Consultation Response from KC Waste Strategy (Refuse & Cleansing)		
PA no. & address: 2021/93270 Land at, Station Road, Skelmanthorpe, Huddersfield, HD8 9BA		
Proposal: Discharge of conditions 3 (construction management), 4 (temporary drainage), 5 (temporary waste arrangements), 7 (adoptable roads), 12 (waste storage and collection), 13 (tree protection), 14 (units 23 and 24 revisions), 16 (detailed drainage scheme), 17 (phase II report), 18 (remediation strategy), 23 (materials) and 31 (vegetation removal) of previous permission 2019/91657 for erection of 30 dwellings		
Date Responded: 09/09/2021	Responding Officer: Carol Oakden	Responding Ref: WPN-21-017
NOTES/COMMENTS: The following comments are made without prejudice and purely from the point of view of the Waste Collection Authority in relation to condition 5 (temporary waste arrangements) and condition 12 (waste storage and collection). Condition 5: The applicant has split the site into 2 phases for temporary waste collection. The first phase plan shows a single collection point close to Station Road and the phase 2 plan suggests a single collection point halfway down the access road. These may be acceptable locations for was

SITE LAYOUT PLAN - Scale 1:500@A2

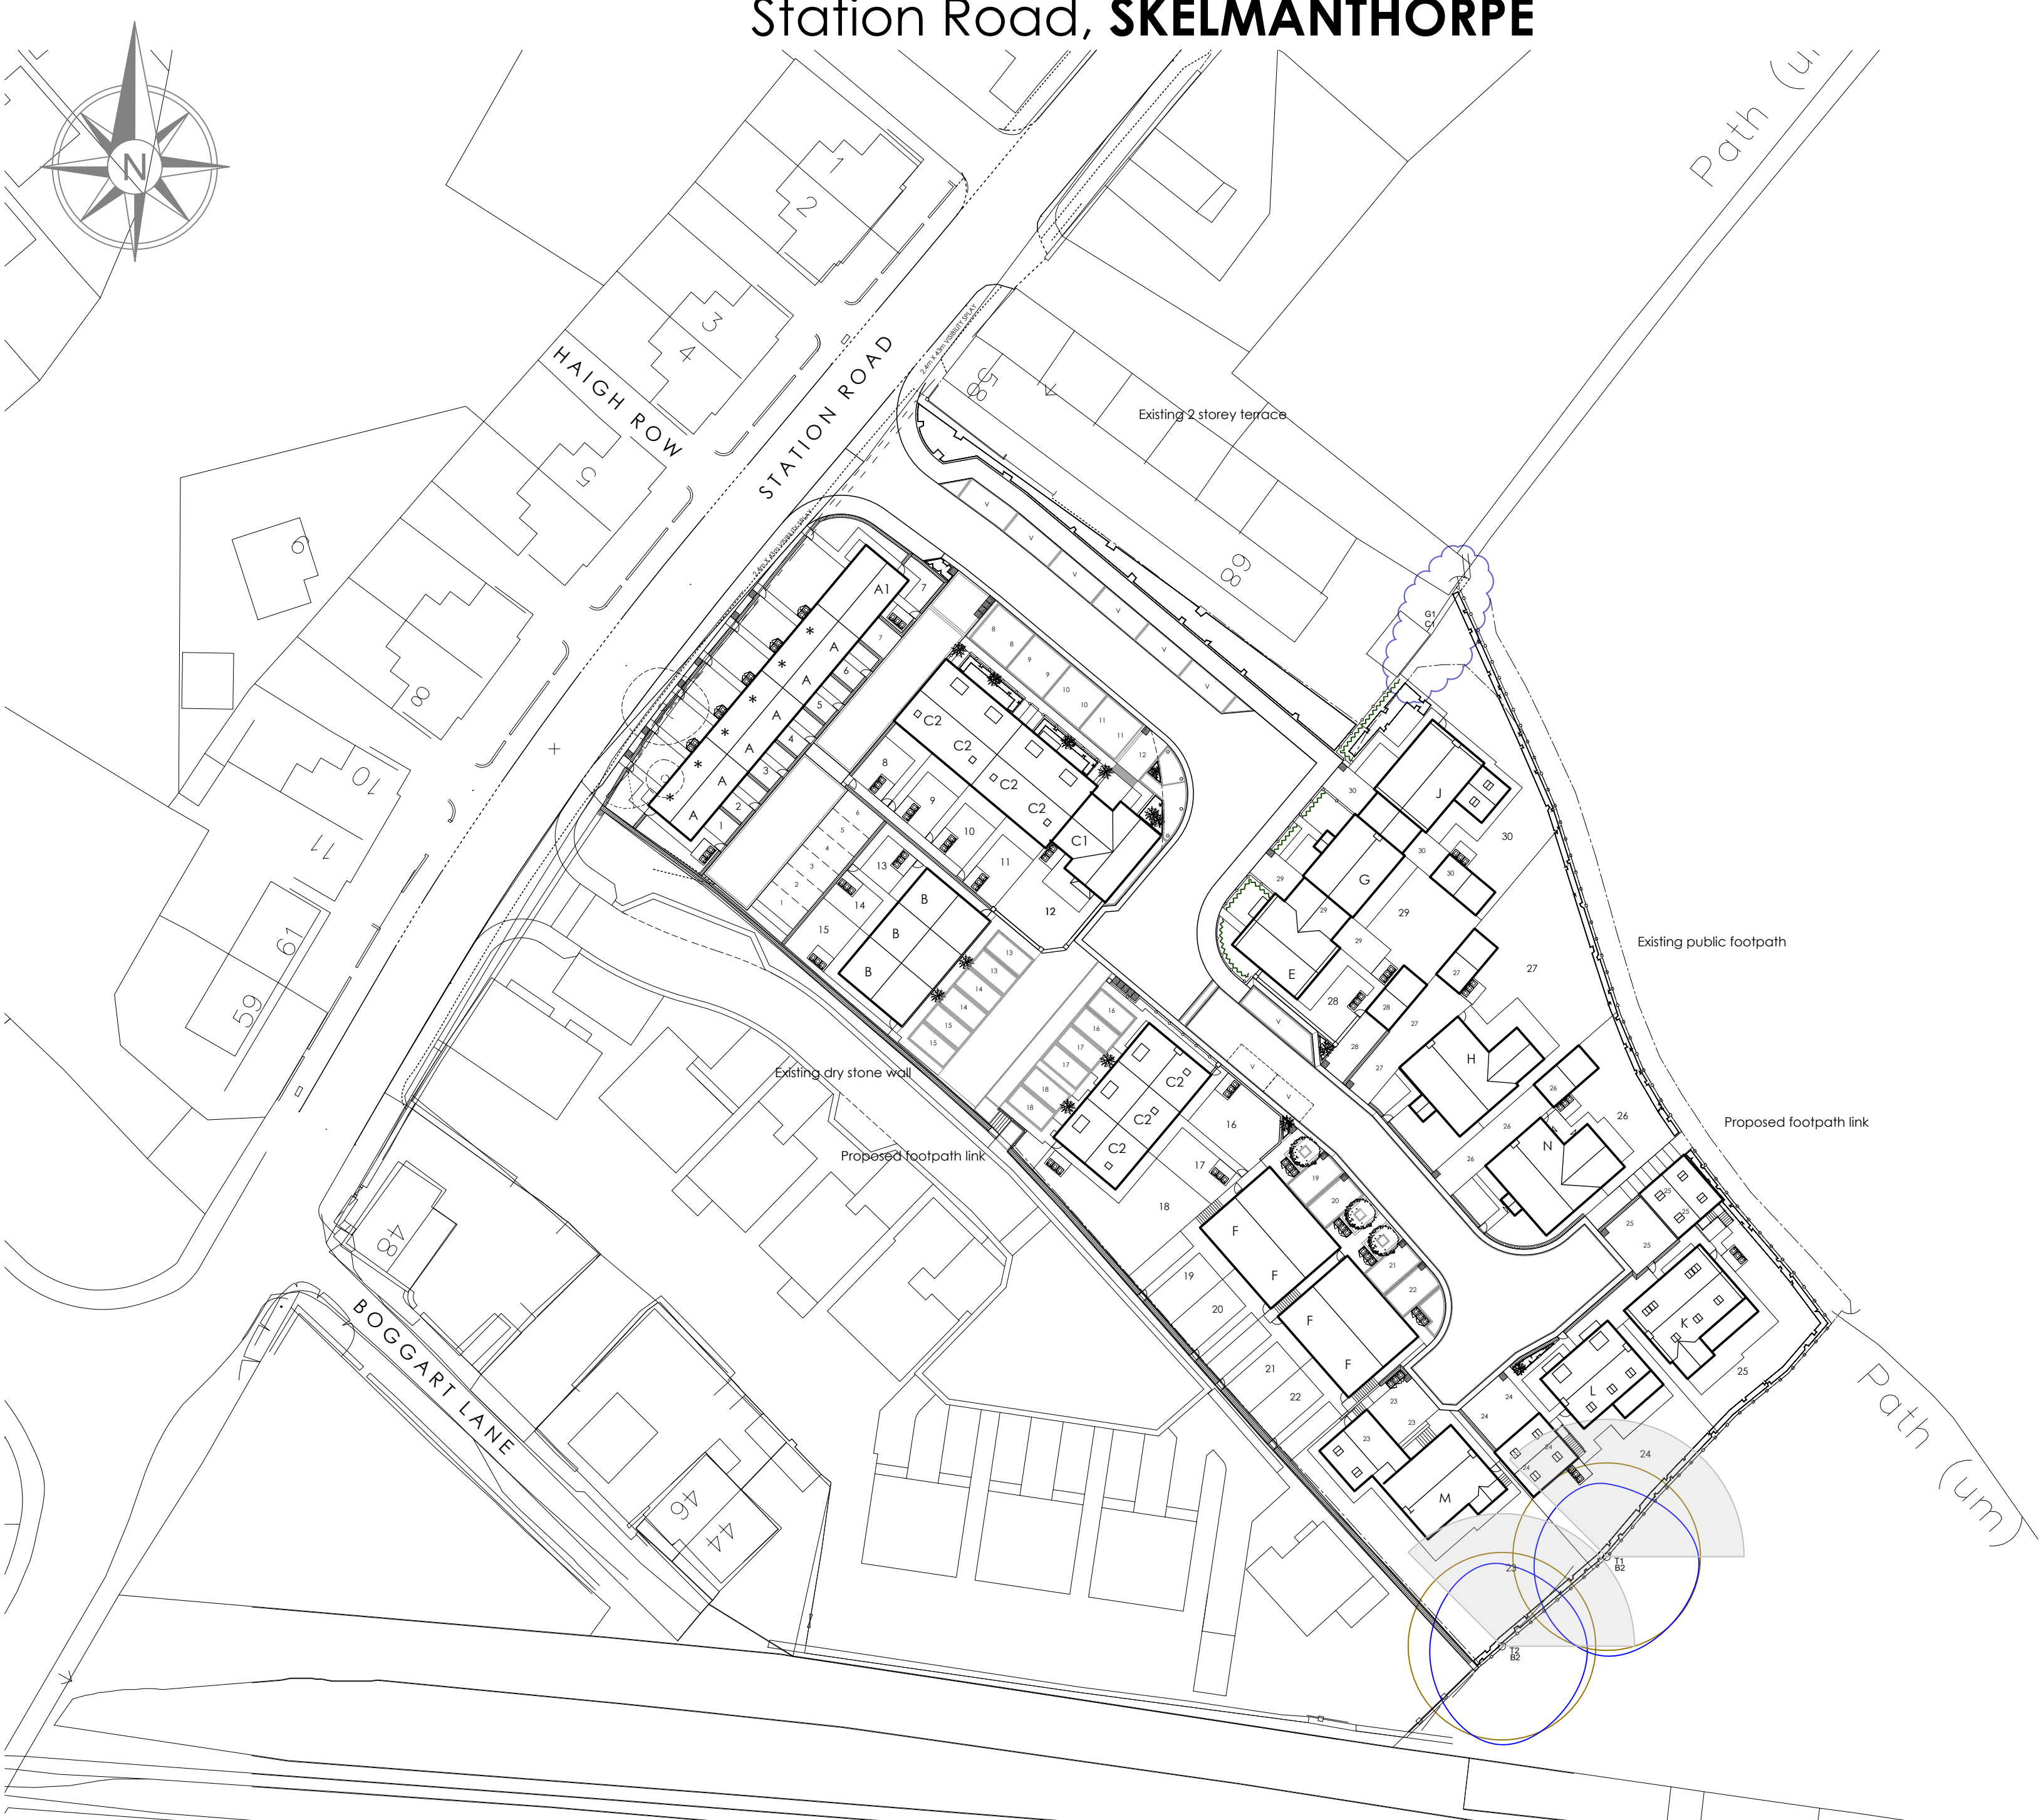
- Plots 8 to 12 have accessible rear gardens for storage (with the exception of plot 12 which has no gate?) but limited space to the front for collection. These plots need an accessible communal presentation point located close to the adopted access road without causing obstruction.

- Plots 13 to 18 have similarly difficult access and storage potential, and bins are likely to be stored to the front, blocking parking or in front of windows and causing unsightly bin blight in the street and potential for unauthorised use.

- Plots 19 to 22 look to have collection points indicated to the front but rear gardens for these plots are accessed up/down multiple steps – bins will need to be stored to the front of these properties without causing bin blight in the streetscene. It is not clear where this will be possible without blocking driveways or being in front of windows.

- Plots 23 to 25 have stepped access to the rear gardens and limited space to the front for the storage of bins.
- Plots 26 to 30 appear to have level, private rear gardens suitable for bin storage along with private driveways for collection.

Without clearer intentions for bin storage and collections, it is likely that waste will become an issue for residents and collection crews, attracting complaints to the Authority, bin blight in the street, unauthorised bin use and potentially theft/damage to bins. There will be little opportunity to properly solve the issues once the site is built.

In conclusion, conditions 5 and 12 cannot yet be discharged to the satisfaction of the Waste Collection Authority.
